Application No: BE/18/26/PL
Site Address: Land West of 26 Greystone Avenue Bersted PO21 5EA
Description of works: Erection of 1 No. detached four-bedroom dwelling (self build) with associated car parking, bike store and landscaping. This application is in CIL Zone 4 and is CIL Liable as a new dwelling.

Thank you for your internet representation made on 9th April 2026 which has been recorded as an objection with the comments as follows:

A :: Propopsed South East Elevation
01 scale: 1:100

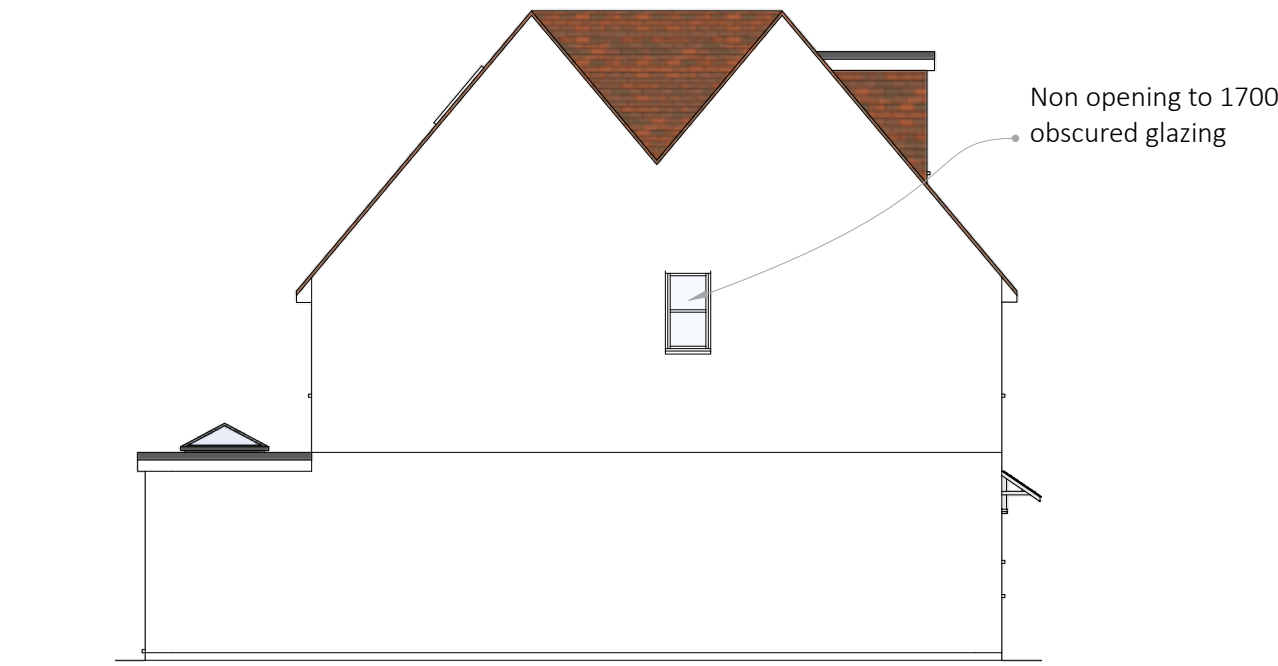
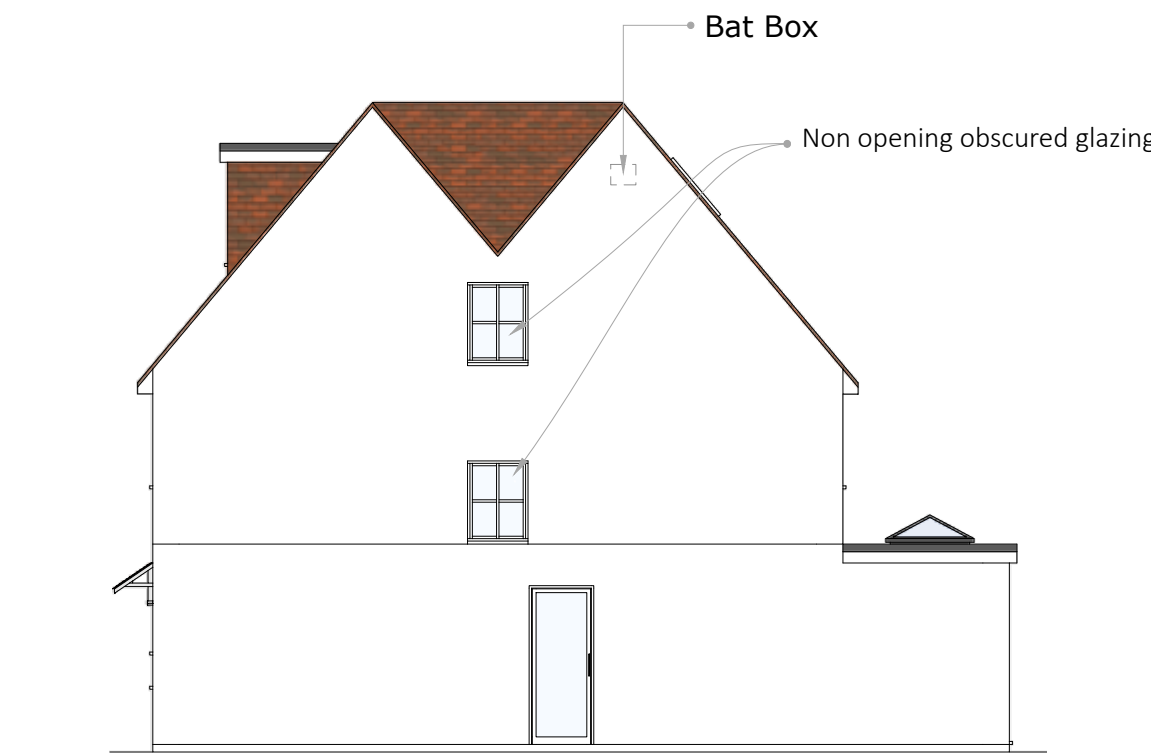
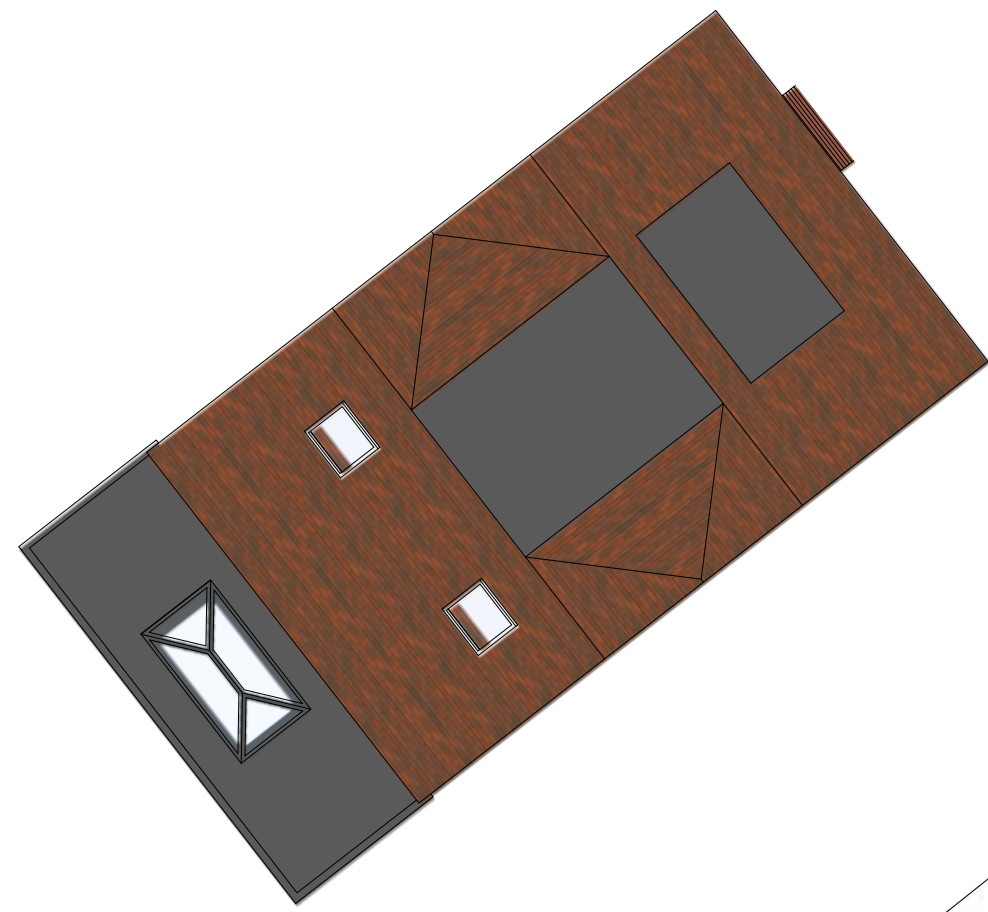
OBJECT for the following: the 3-storey design is not in keeping with the character of the area and will overshadow and be overbearing on the bungalow at 26 Greystone Avenue contrary to Bersted Neighbourhood Plan policies ES5 and HDQ4 and Arun DC Policy D SP1. The loss of habitat from removing hedgerows and trees is contrary to Arun DC Policy ENV SP1. The Parish Council also has concerns that the drainage ditch that runs along adjacent to 25 and 26 Greystone Avenue has been filled in at the applications proposed site and could cause flooding. The Parish Council asks that a drainage officer investigates this before a decision is made. Historical maps have been submitted showing the drainage ditch.
